Christina Stacey - Re: Fw: Fwd: Permit #2248 - 83 Woodford St.

From: Christina Stacey
To: Mitchell, Kristen
Date: 9/29/2015 3:00 PM
Subject: Re: Fw: Fwd: Permit #2248 - 83 Woodford St.
CC: Bagshaw, John

I am reviewing your application for interior renovations and a deck addition at the above-referenced property. I did have one question - there are a couple plans that were submitted for a second-floor deck, but this cannot be approved under the fast-track process. Did you want to get approval for the second-floor deck now, or were you planning to submit a separate non-fast-tracked application for that later? Please let me know.

Proposed  
2ND  
STORY DECK

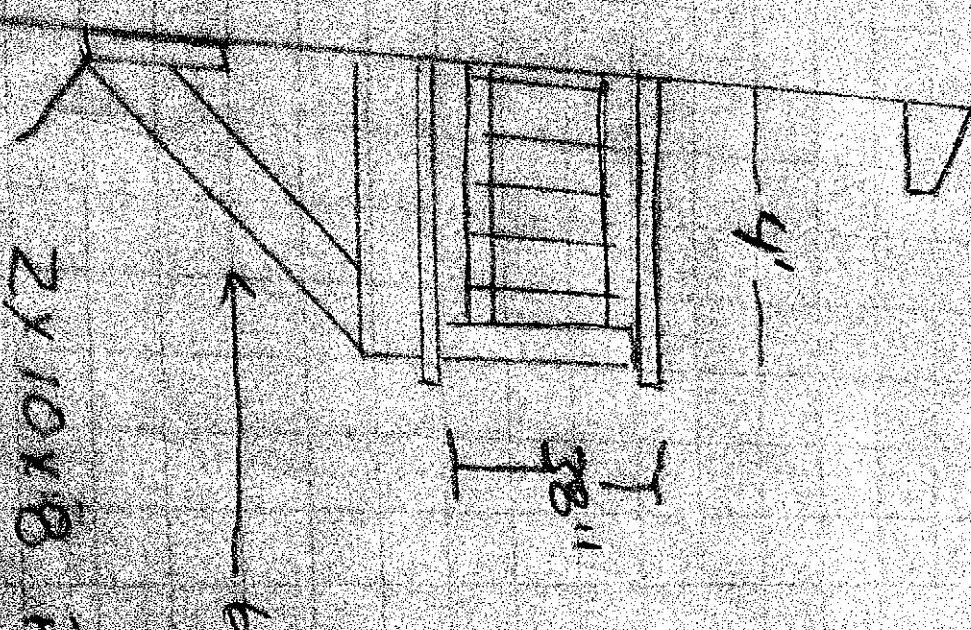
The rest of the permit looks approvable under fast-track, so if you want to withdraw the second story deck from your proposal, I think I could sign off on the rest today. If the second story deck remains on the permit, the entire project must then be reviewed for code compliance, which would certainly delay it at least another few days. Also, before codes could even start reviewing it, they need more detailed construction plans for everything proposed (decks,

interior work, etc) - all framing details, materials to be used, etc. It may be easier to submit a separate permit for the second story deck with more detailed plans.

Great, thank you for sending these items. I am going to make a note on the permit application and plans that approval for the 2nd story deck is not being sought with this permit. I will finish up review and hopefully get the building permit approved today. I will also move the demo permit forward to the pre-demo inspection phase. Thanks again, and let me know if you have any other questions.

The intention was to have all of the items fast tracked with the exception of the 2nd floor deck so we will call Laurie and get the additional information that is needed from her asap and have the remaining items be a separate permit.
